Our reference: DCO/2013/00011

11 December 2018

RE: REQUEST TO INCREASE HAMMER ENERGY FOR SOFIA OFFSHORE WIND FARM (SOWF) (FORMERLY DOGGER BANK TEESSIDE A&B).

Figure 1: SOWF UWN modelling in relation to Flamborough Head spawning ground

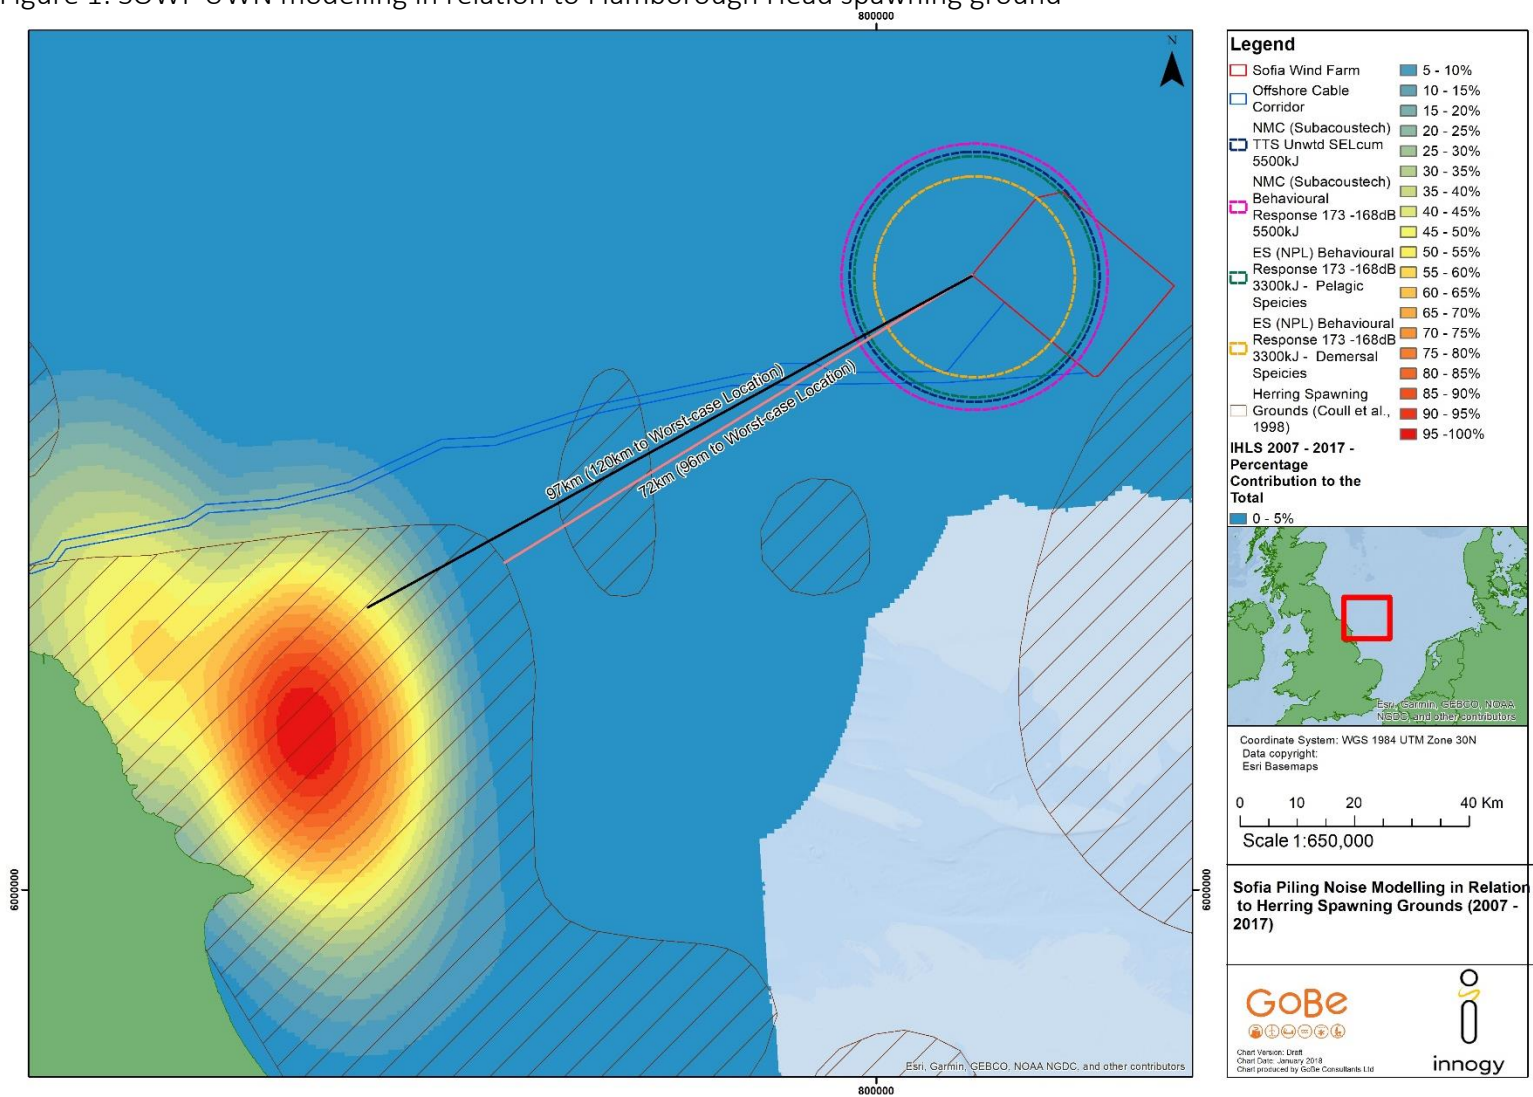
- 2.1.4. The impact ranges presented in Figure 1 of the SoCG predict that effects of noise and vibration will extend to the outer areas of broad-scale habitat for herring spawning, based on Coull *et al.* (1998).

- 2.1.5. However, by taking an evidence based approach using 10 years of International Herring Larvae Surveys (IHLS) data, herring larvae are shown to be in their highest concentrations further west, towards Flamborough Head.

- 2.1.6. Using the modelled data presented in Appendix A to the SoCG, the distance between the closest point of predicted impact range and the higher concentrations of herring larvae is approximately 20-30km. The MMO considers that the distance offers gravid herring and their eggs and larvae some additional buffer against potential impacts of noise at the SOWF. However, MMO also recognises that herring spawning grounds can be recolonised over time, and the exact locations for herring spawning change year on year, so there is potential for spawning activity to extend eastwards towards SOWF.

- 2.1.7. Consequently, the MMO does not agree that the impact of underwater noise is negligible, and that impacts to gravid herring and their eggs and larvae are still possible. However, the MMO does consider that the supporting information adequately demonstrates that the risk of a significant impact is unlikely to be high, and is therefore is content that the increased hammer energy of 5,500kj
